Project # 1009982

RE: project 1009982, 14EPC- 40012 and 14EPC-40014

FEDEX GROUND ALBUQUERQUE

**RE: RESPONSES TO EPC CONDITIONS OF APPROVAL
FEDEX GROUND EPC PROJECT # 1009982
14EPC-40012 SITE DEVELOPMENT PLAN FOR SUBDIVISION
14EPC-40014 SITE DEVELOPMENT PLAN FOR BUILDING PERMIT**

5-20-14 100% REVIEW SET NOT FOR CONSTRUCTION	FEDEX GROUND ALBUQUERQUE, NM LANDSCAPE PLAN FOR BUILDING PERMIT	DRAWN BY VT DATE 5/20/14 FEDEX_LANDSCAPE BASE
	 TIERRA WEST, LLC 5571 MIDWAY PARK PLACE NE ALBUQUERQUE, NM 87109 (505) 858-3100 www.tierrawestllc.com	SHEET # L2 JOB # 2013075

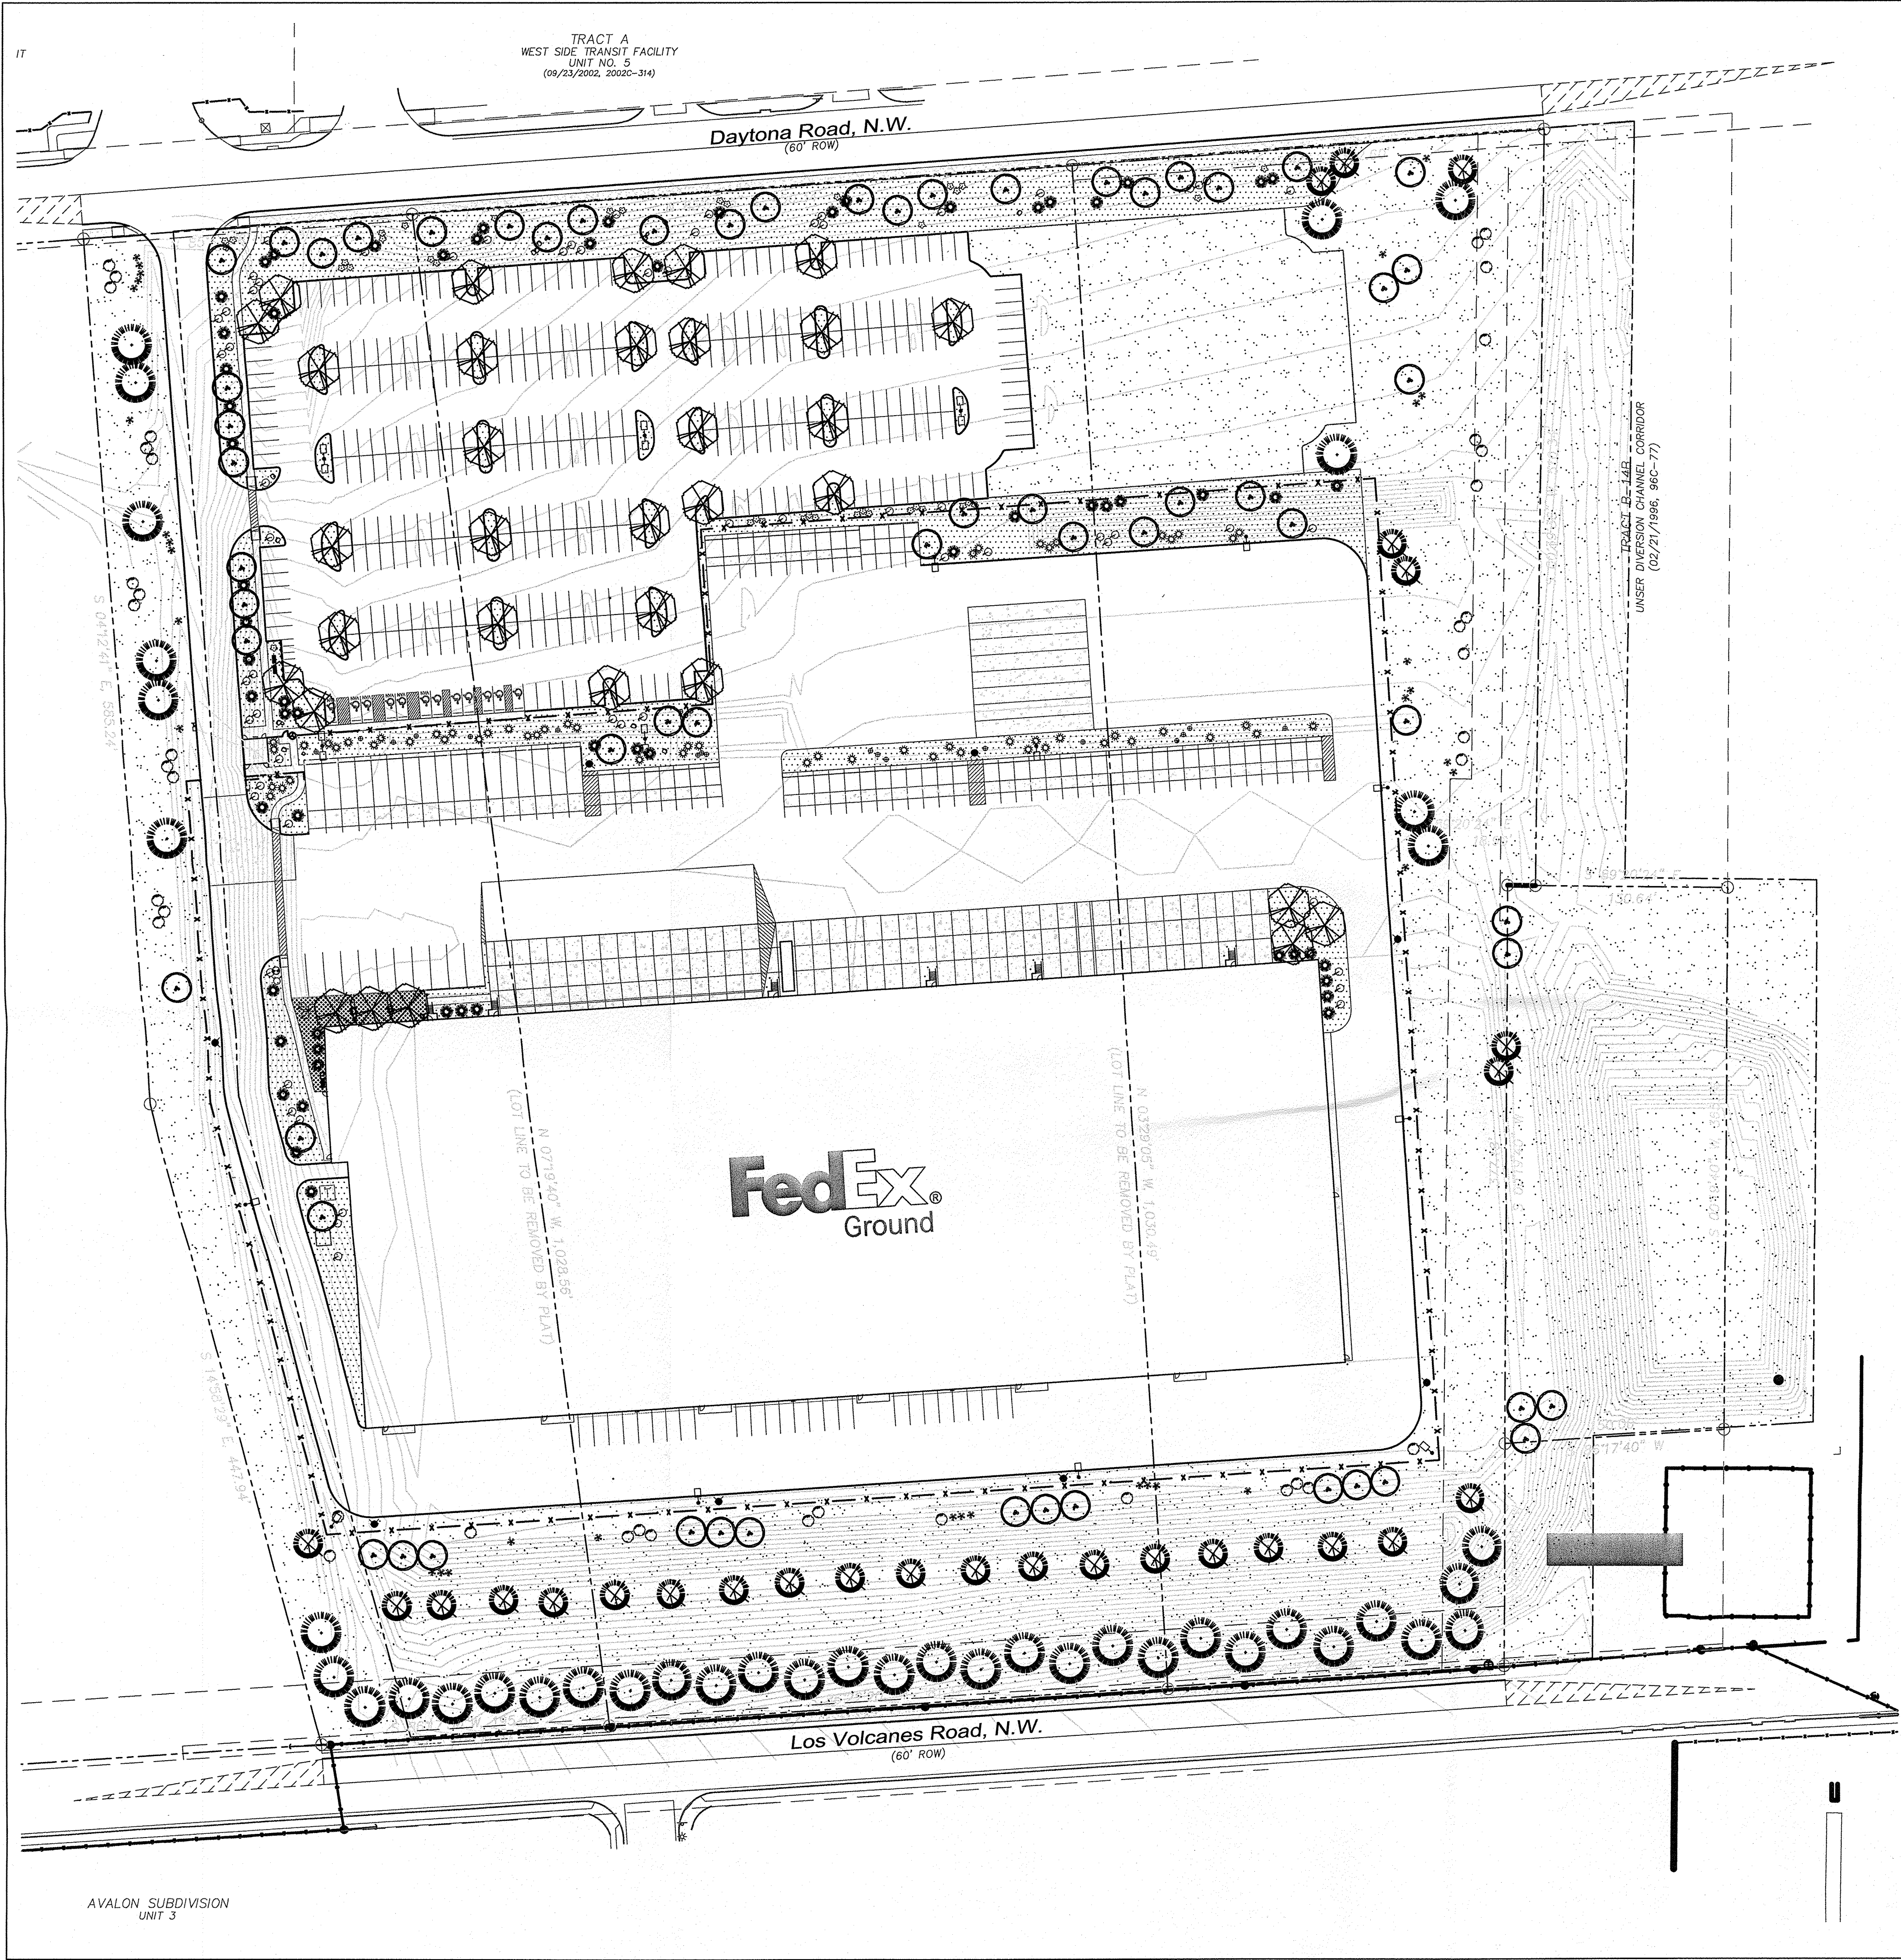
Staff agreed that the conditions had been met except that the landscaping plan lacked the required details for employee break area. This was added to the DRB submittal, but is difficult to read. The applicant will include an updated landscape plan for final sign off at DRB
